**EL PASO COUNTY PLANNING AND
 COMMUNITY DEVELOPMENT
 DEPARTMENT**

STORMWATER MANAGEMENT PLAN CHECKLIST

**C1**

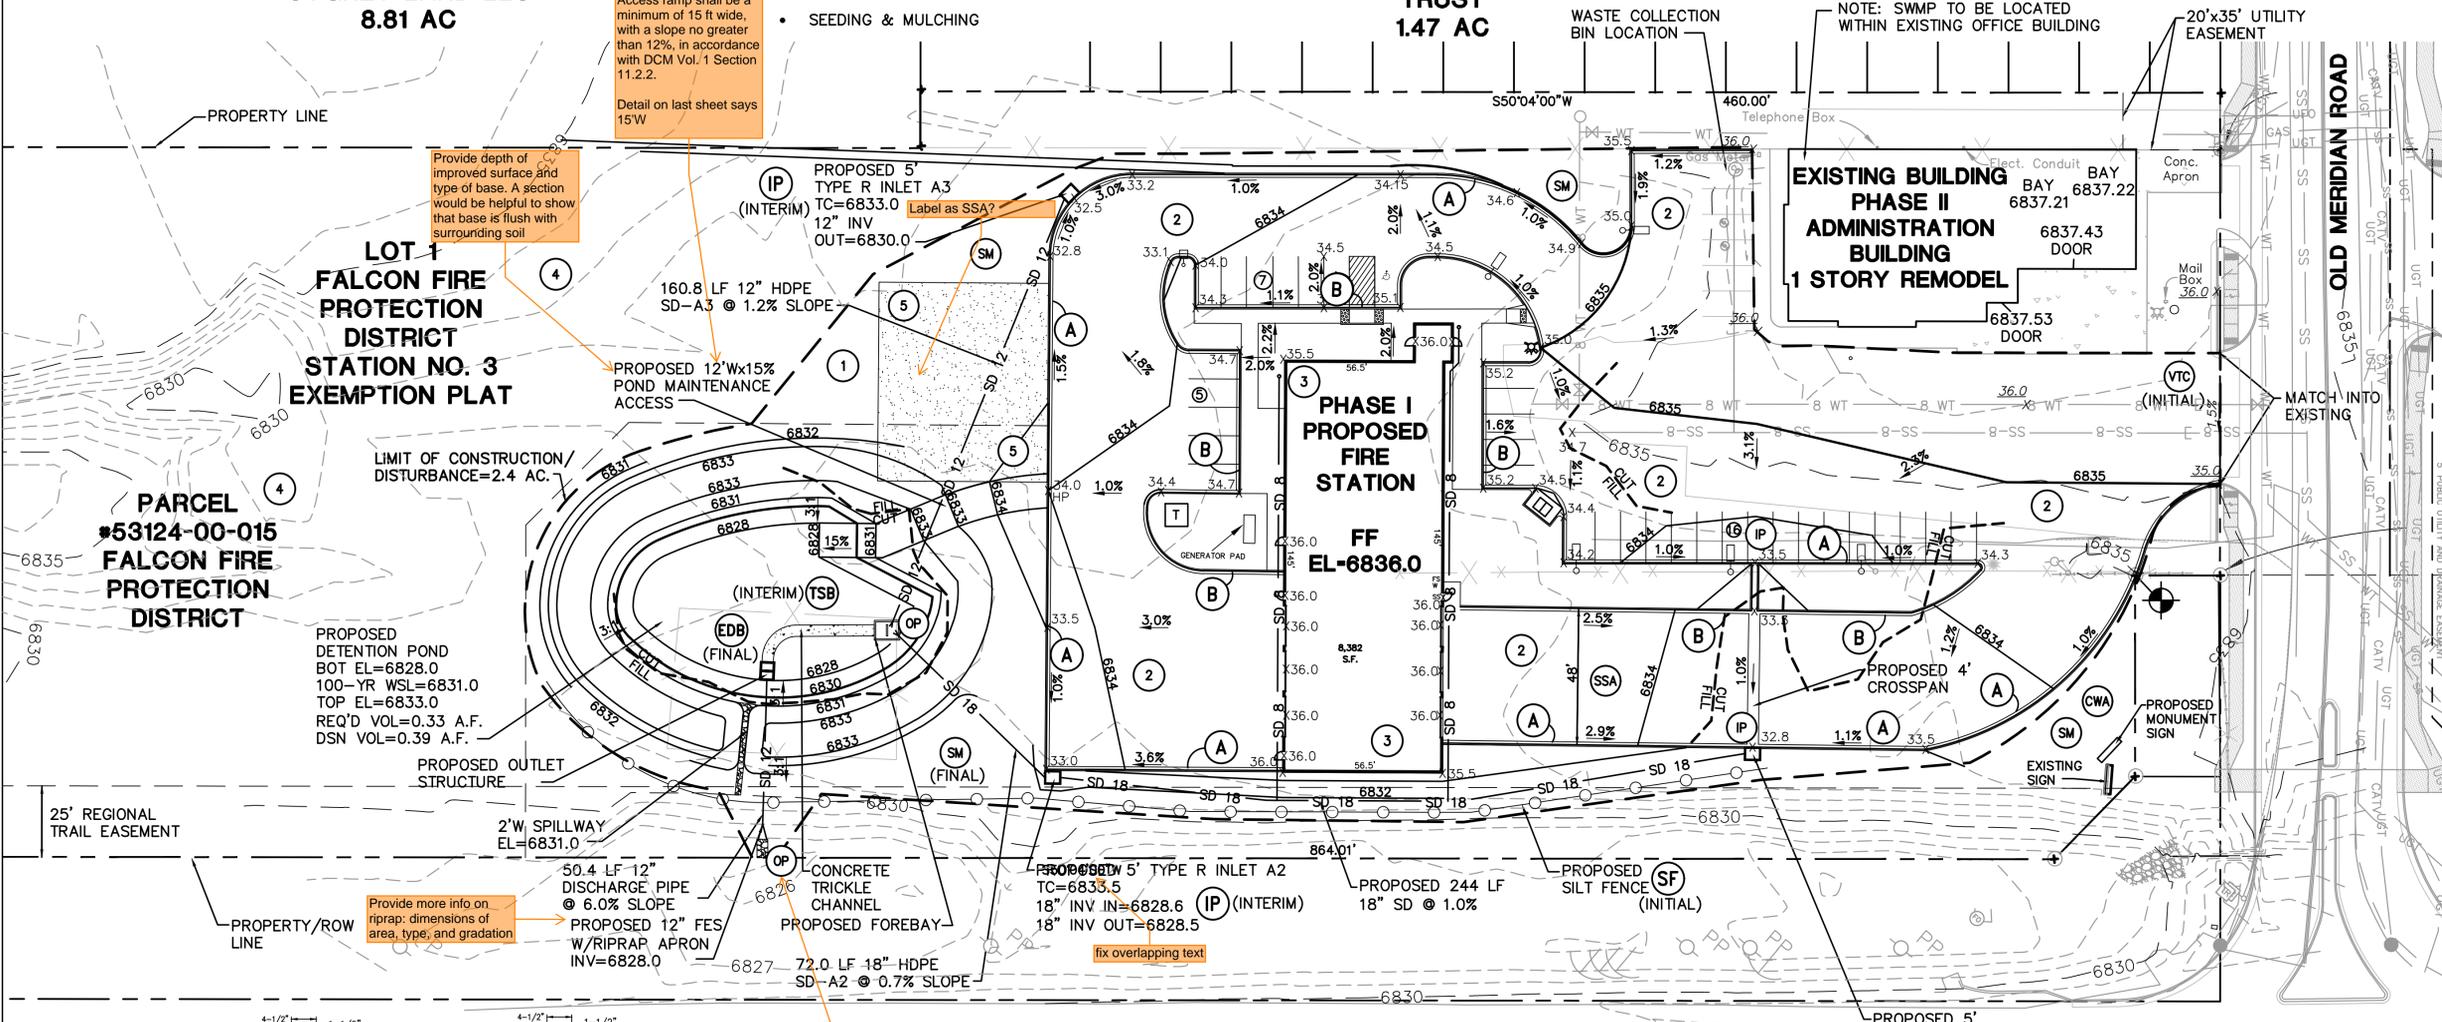
Revised: July 2019		Applicant	PCD
17	SWMP Map to include:	Y	
17a	construction site boundaries	Y	✓
17b	flow arrows to depict stormwater flow directions	Y	✓
17c	all areas of disturbance	Y	✓
17d	areas of cut and fill	Y	✓
17e	areas used for storage of building materials, soils (stockpiles) or wastes Locate SSA on plan	Y	X
17f	location of any dedicated asphalt / concrete batch plants	Y	✓
17g	location of all structural control measures Locate SCL on plan if applicable	Y	X
17h	location of all non-structural control measures	Y	✓
17i	springs, streams, wetlands and other surface waters, including areas that require maintenance of pre-existing vegetation within 50 feet of a receiving water	Y	✓
18	Narrative description of all structural control measures to be used. Modifications to EPC standard control measures must meet or exceed County-approved details.	Y	✓
19	Description of all non-structural control measures to be used including seeding, mulching, protection of existing vegetation, site watering, sod placement, etc.	Y	✓
